Sent: 21 October 2013 20:48
To: Planning
Subject: Re: 5 Orchard Close, Cuffley - Your Ref: S6/2013/1884/LUP

Re: Erection of Two Storey Side and Rear Extension, Loft Conversion and Front Bay Windows at 5 Orchard Close, Cuffley, Potters Bar

PROPOSED FRONT ELEVATION

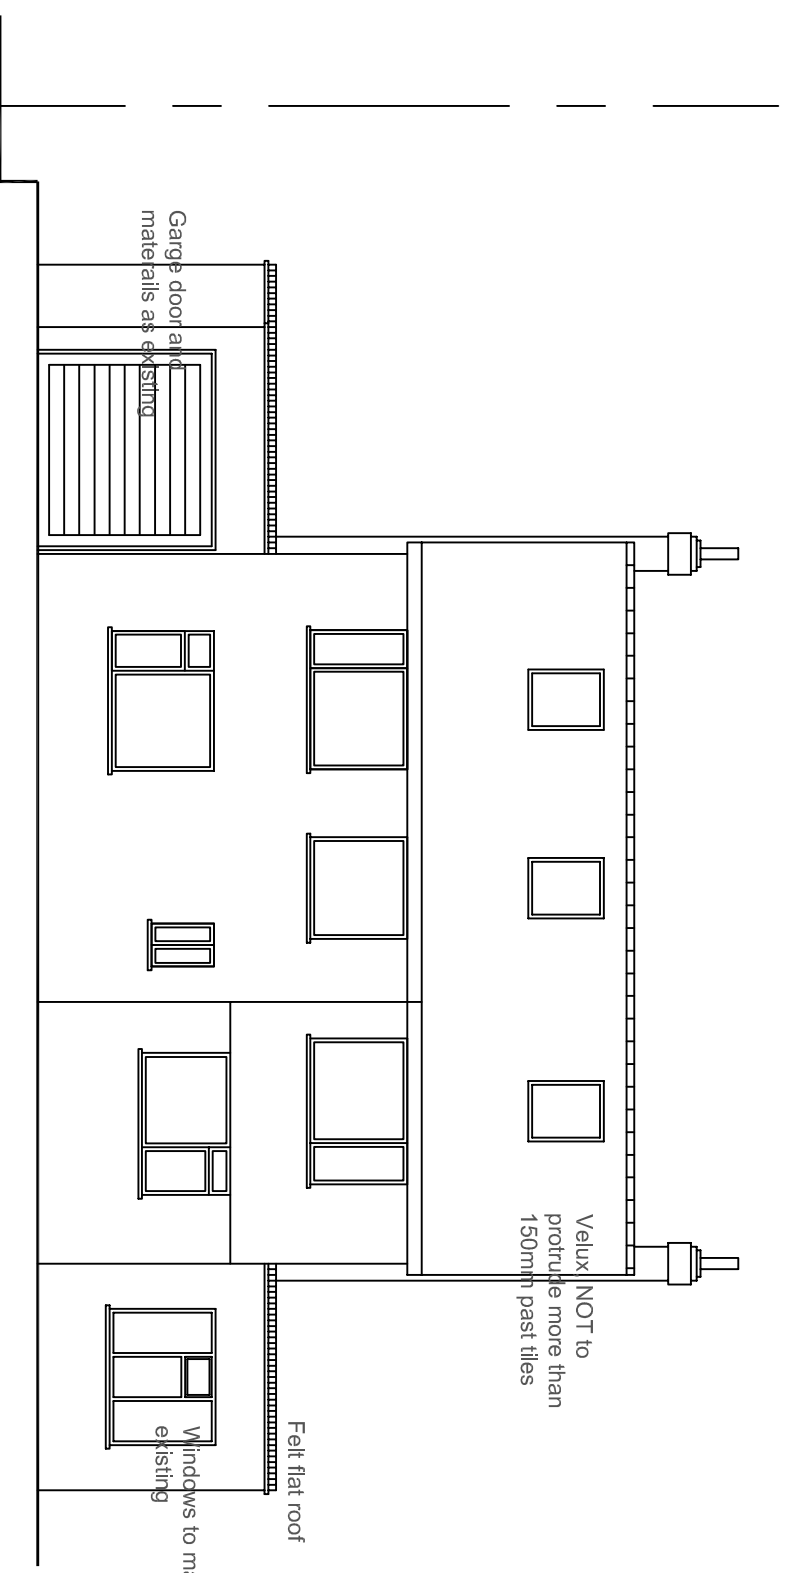
The proposed bays to the front of the property are now shown as being formed by windows. The side window of the front right upper bay will directly overlook our main living areas (those being our lounge and dining rooms) infringing upon our privacy and our personal space.

PROPOSED REAR ELEVATION

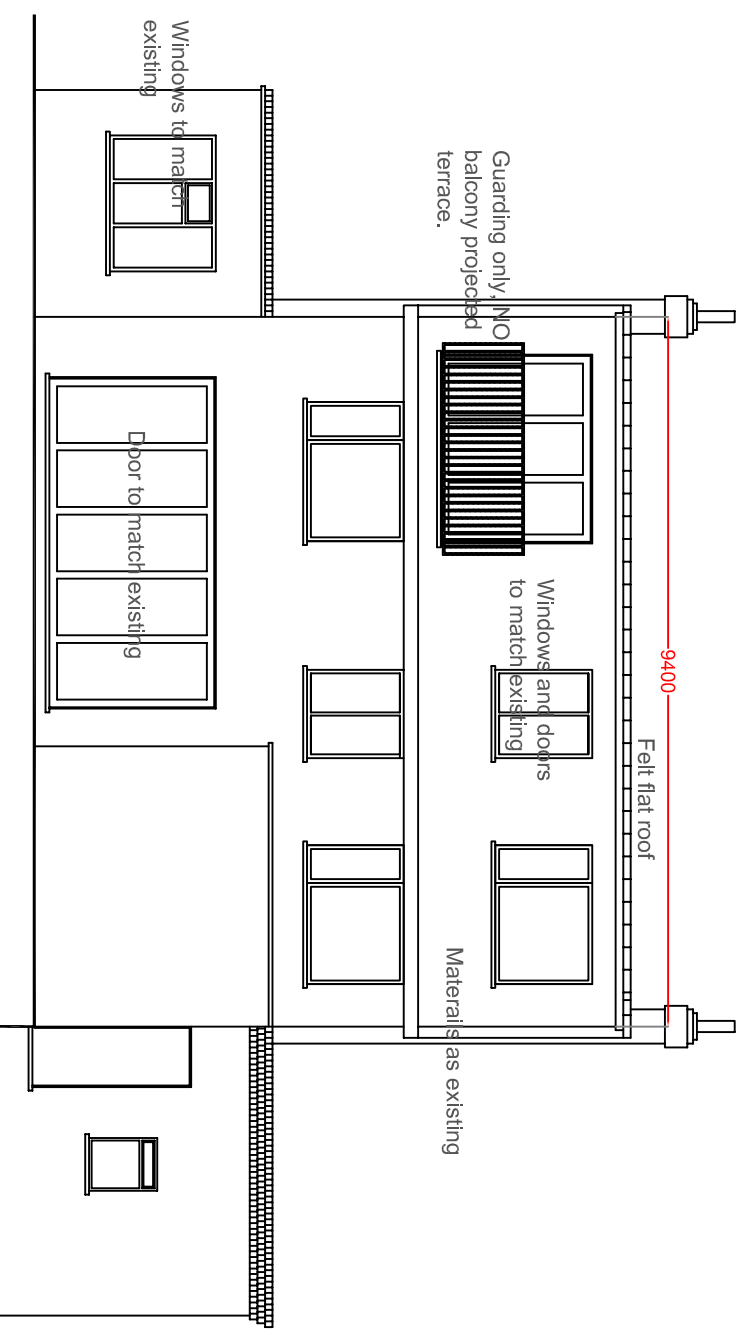
Similarly, the amended dormers to the rear of the proposed property, despite being reduced in number from three to two, are now individually larger so their potential for overlooking neighbouring back gardens remains effectively the same.
